Ref: 2025/0393  
Date: 27<sup>th</sup> May 2025  
Enquiries Jess Duffield  
Direct 01226 772589  
E-Mail: jessicaduffield@barnsley.gov.uk

**RE: Discharge of condition 9 and 15 relating to 2024/1060: Alterations to existing car park and provision of new public open space and landscaping with associated works.**

Thank you for submitting an application for the discharge of condition 9 (Substation elevations) and condition 15 (street furniture and signage) of planning application 2024/01060.

Wayfinding Totem WT.100
DI-WT.05
Design Intent 015

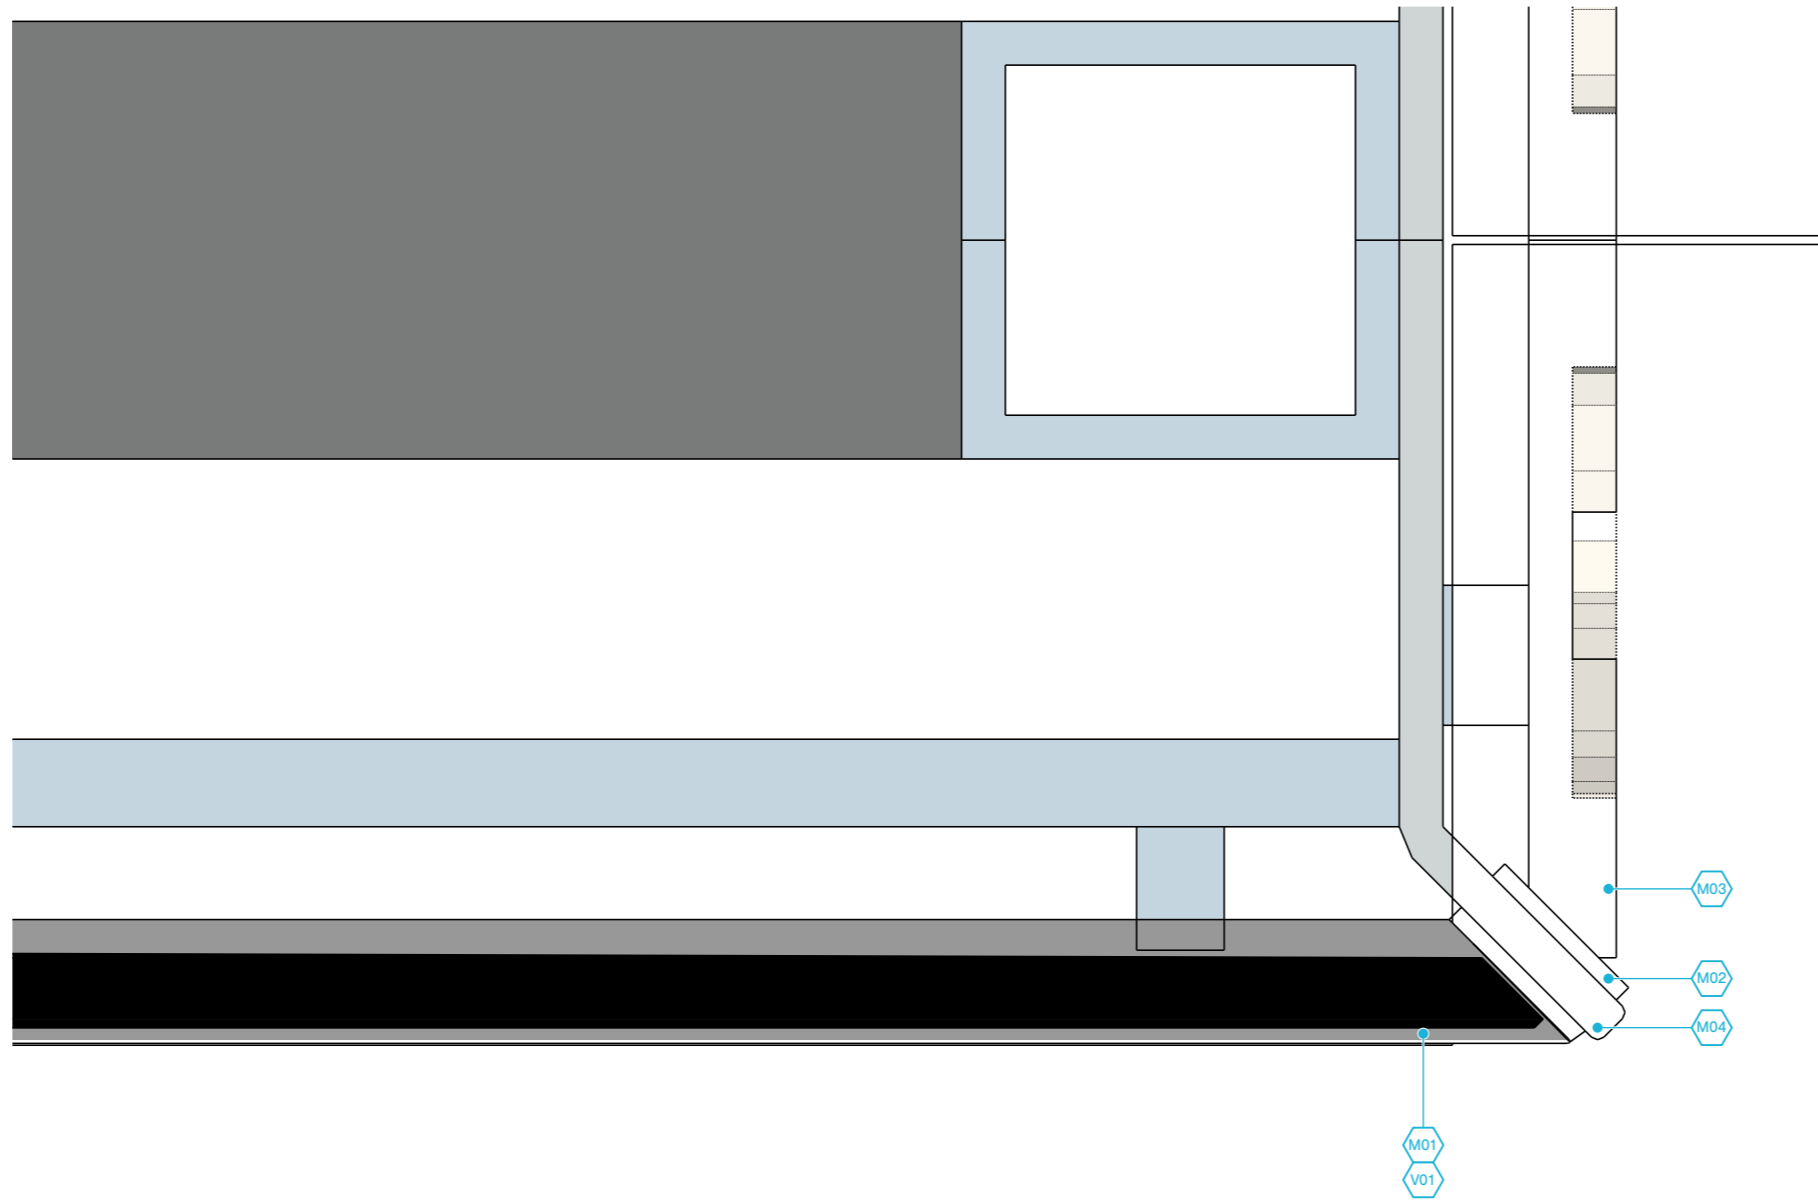
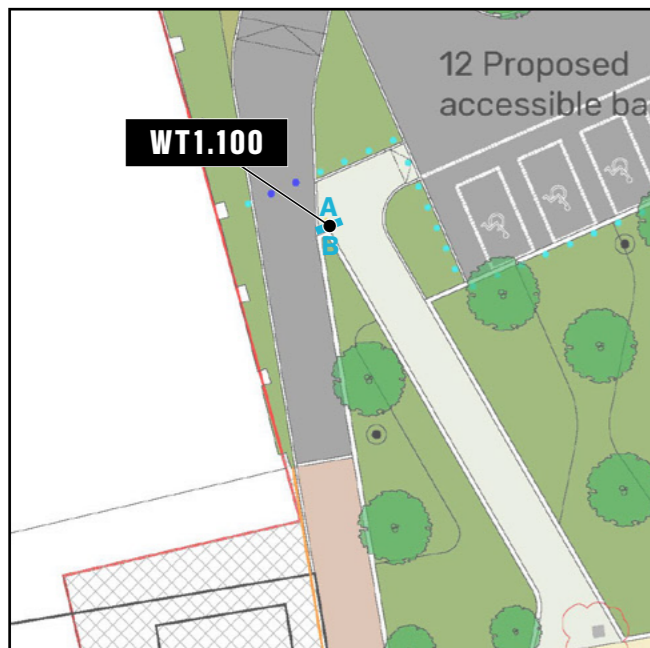
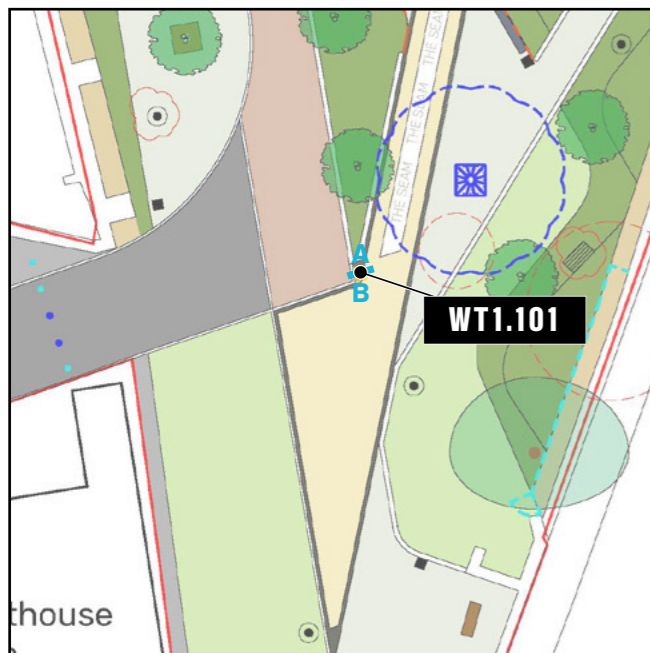
*The Urban Design Officer has reviewed the submitted information and is generally supportive of the proposals. However the colour of some details is unclear and therefore to discharge the condition in full, confirmation regarding the colour of the automatic/fixed bollards and the frame of timber benches and metal benches is required.*

CONDITION 15 – DISCHARGED IN PART

**G.R.P HOUSING
MODEL TR18**

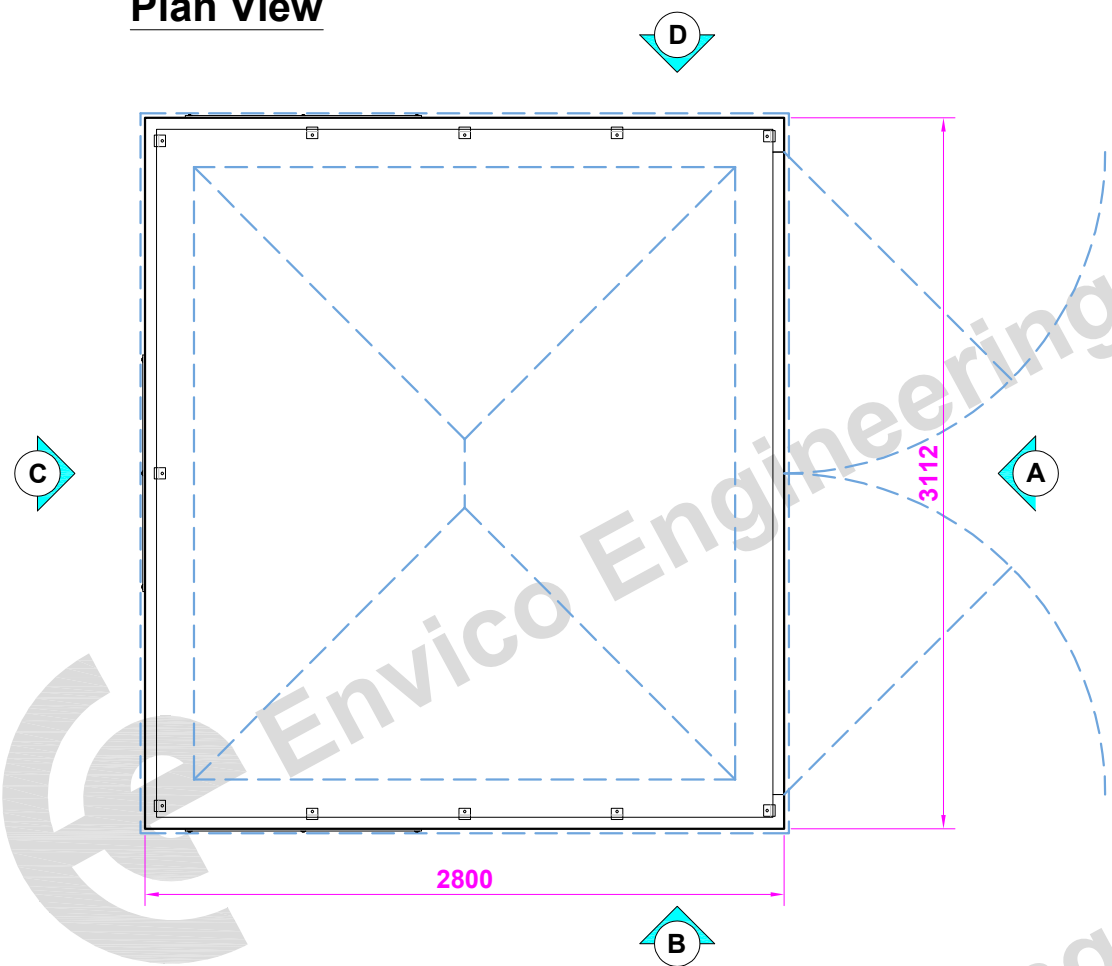
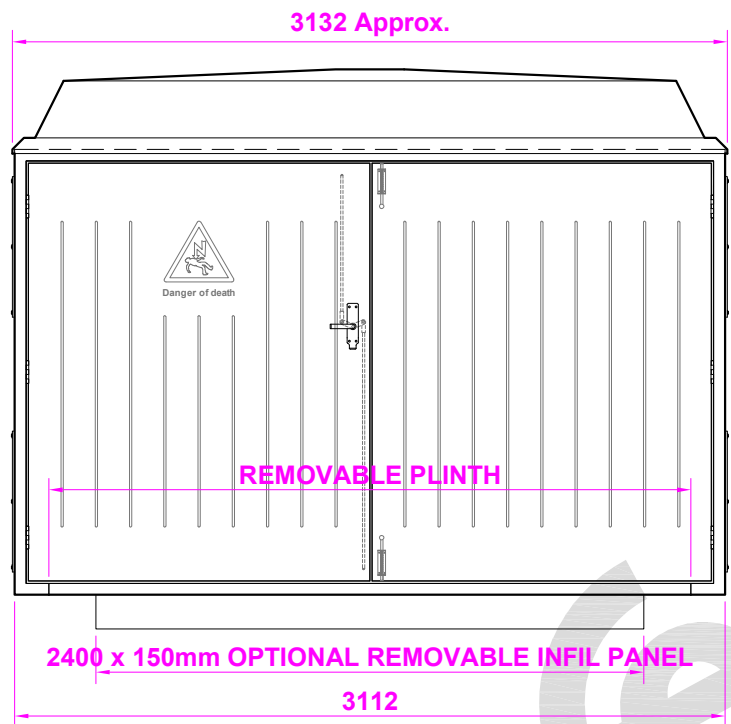
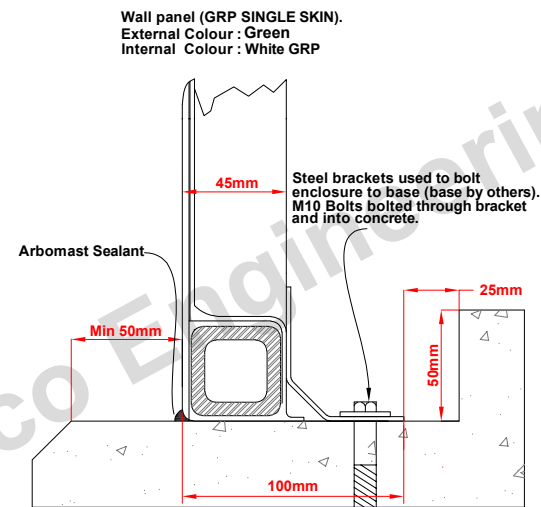
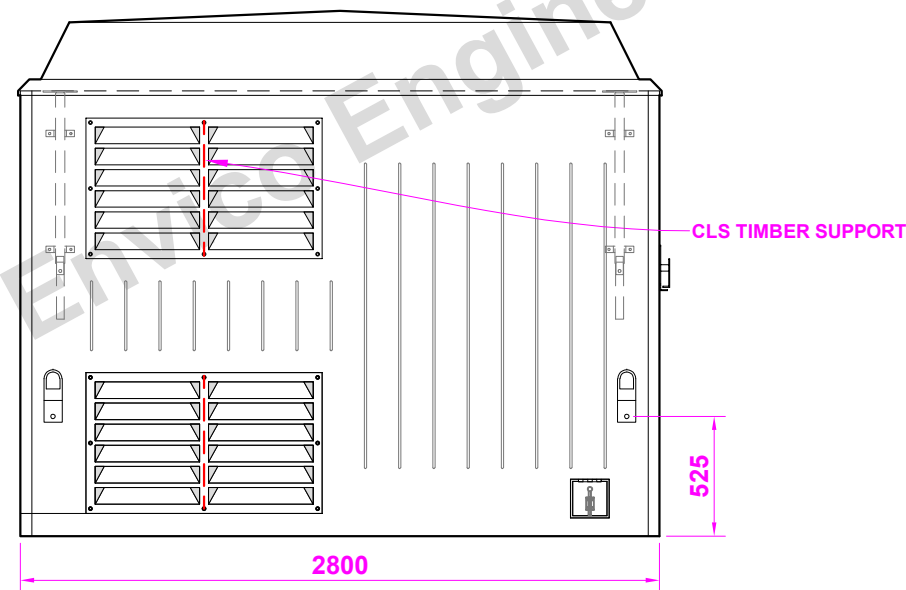
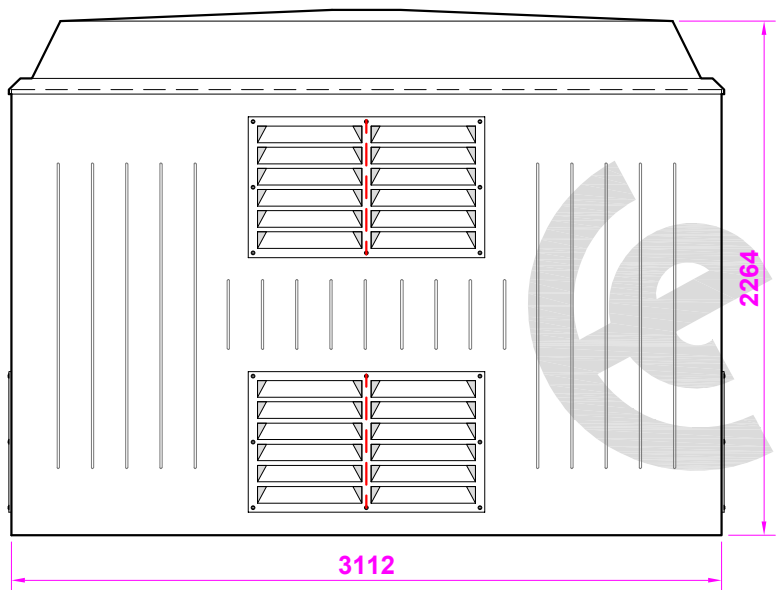
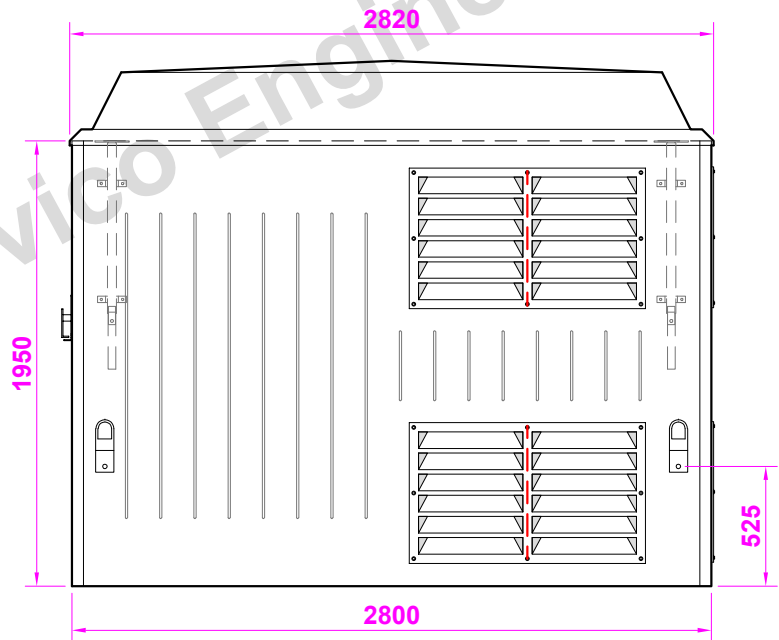
*The Highways DC Officer and Urban Design Officer have reviewed the submitted information, which includes the submission of additional details regarding the position/opening of the gates and the colour. In summary, this condition can be discharged in full.*

**CONDITION 9 – DISCHARGED IN FULL**
